**CITY OF PORTLAND, MAINE
DEVELOPMENT REVIEW APPLICATION
PLANNING DEPARTMENT PROCESSING FORM**

Single Family Home

555 - 555 Auburn St , Portland, Maine

TO: Inspections Department
FROM: Barbara Barhydt, Development Review Manager
DATE: January 31, 2007
RE: C. of O. for #555 Auburn Street
(Id#2006-0088) (CBL 382 A D023)

GRADING PLAN	
DESIGN BY:	MTW
DRAWN BY:	MTW
CHECKED BY:	DLR
DATE:	5-4-06
SCALE:	1"=30'
FIELD BK:	778
PROJ. NO.:	06170
DRAWING:	06170G
SHEET 2 OF 5

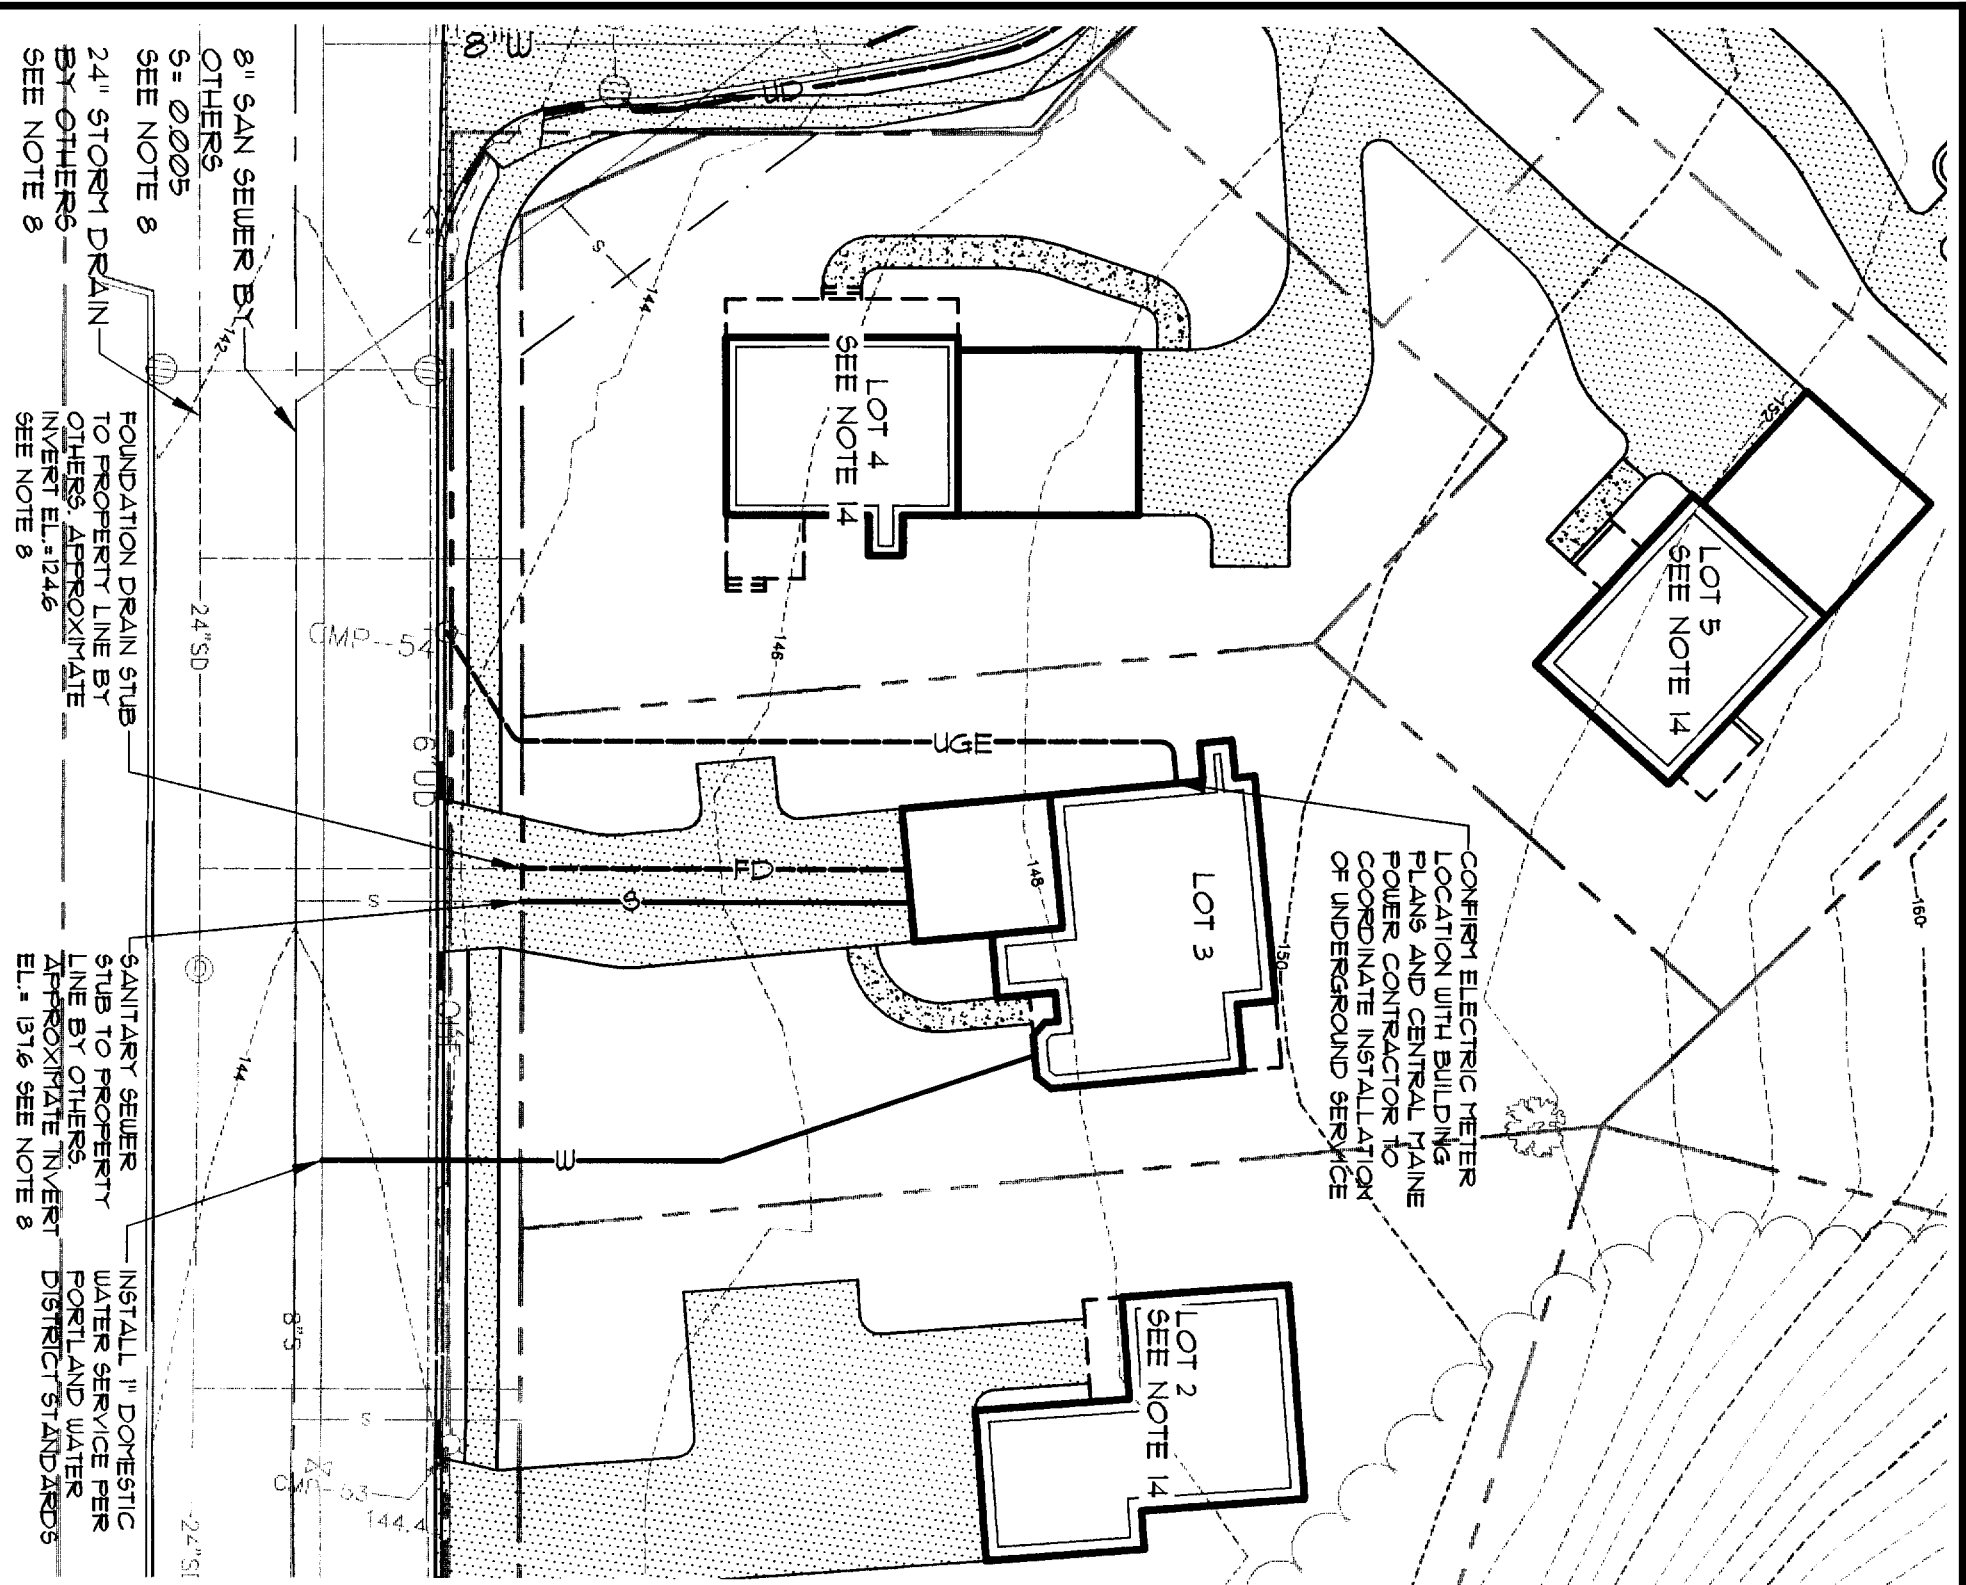
① Look at Grading
 ② " " Sub. Plans
 for Grades/FFE
 ③ Call Dan Riley
 5-17

- 1 **FINAL GRADING SHALL BE DONE SO THAT DRAINAGE IS DIRECTED TOWARD AUBURN STREET.**
- 2 All Site work (final grading, landscaping, loam and seed) must be completed prior to issuance of a certificate of occupancy.

LANDSCAPE PLAN
OF:
LOT 3 AUBURN ESTATES
LONGVIEW DRIVE
PORTLAND, MAINE
FOR:
BRUSH AND HAMMER INC.
110 LESTER DRIVE
PORTLAND, MAINE 04103

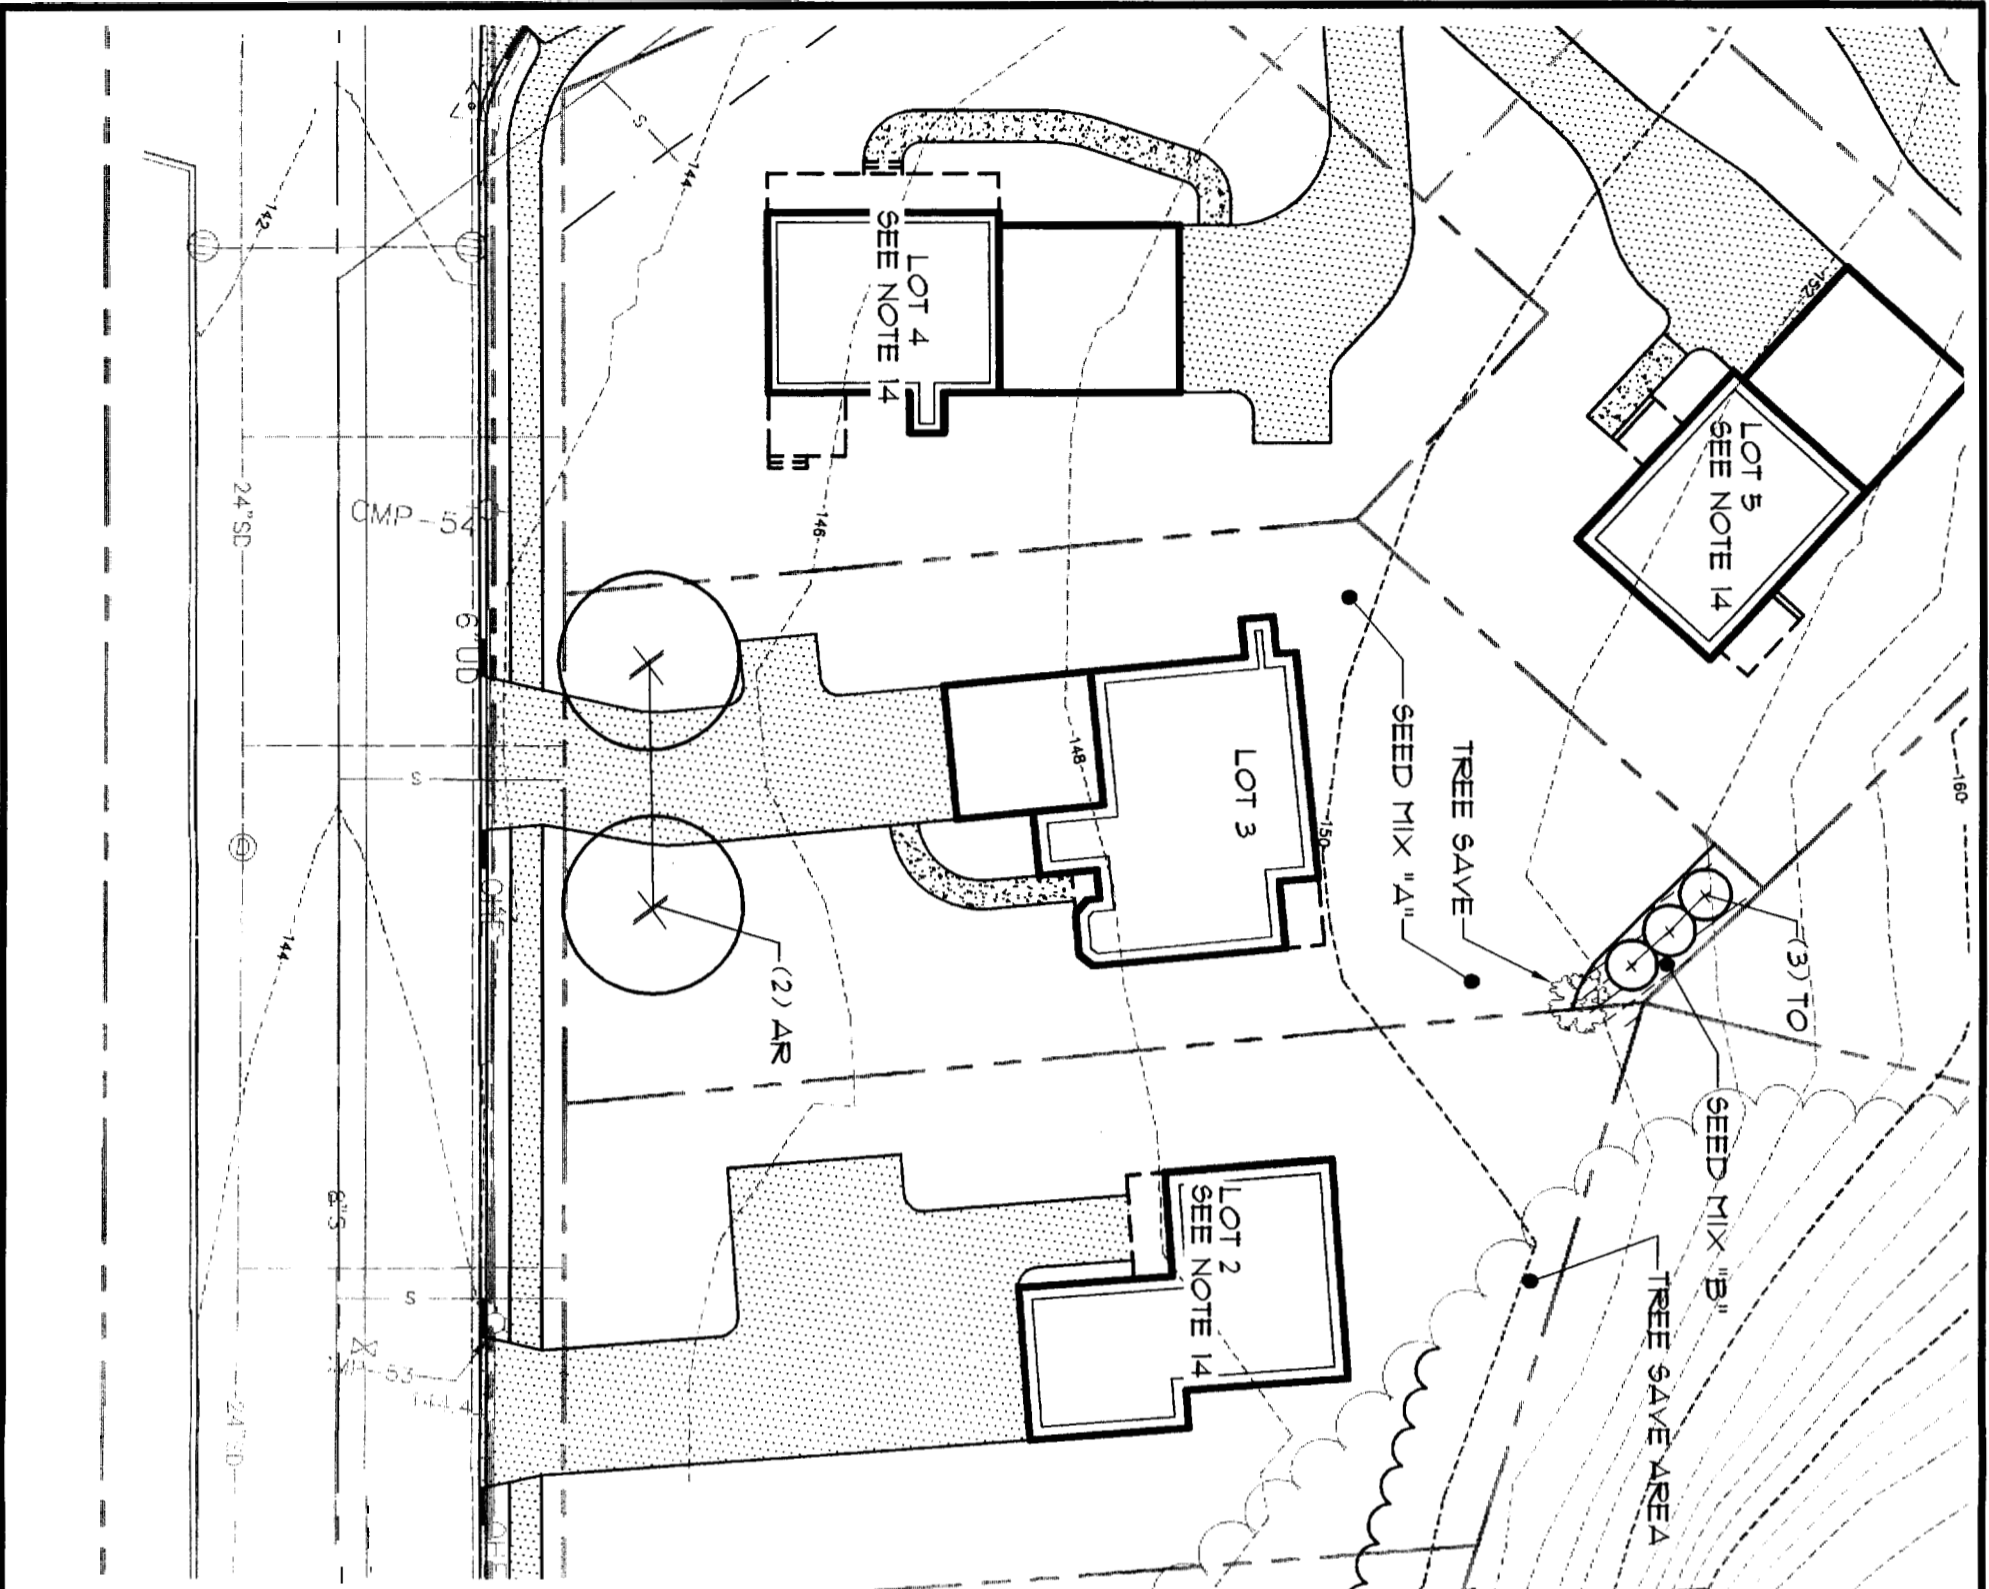
I looked at the site yesterday. The grading appears to be good, directed toward Auburn St. or to french drain. The site work is done except for seeding. All repairs to sidewalk, curb, street etc. appear good. The plans called for 2 trees in front to be 3", they are approx. 1" (too small). Keep in mind that the ground is ice and snow covered and should be inspected again in the spring. I spoke to the developer and voiced my concerns about the size of the trees. He said that if it was a problem, that he would replace them in the spring. He will also be seeding in the spring. I would recommend a temporary C of O pending seeding, tree replacement and final inspection in the spring.

Two undersized street trees are installed, so the trees must be replaced with two trees of a minimum of three inch caliper meeting the City's Arboricultural standards prior to the final certificate of occupancy.

1. Loaming, seeding, and mulching of all disturbed and sparsely grown areas,
2. Two (2) City of Portland approved species and size trees must be planted on your street frontage. In order to meet the City's Arboricultural standards the trees must be a minimum 2 to 2 ½ inch caliper in size.
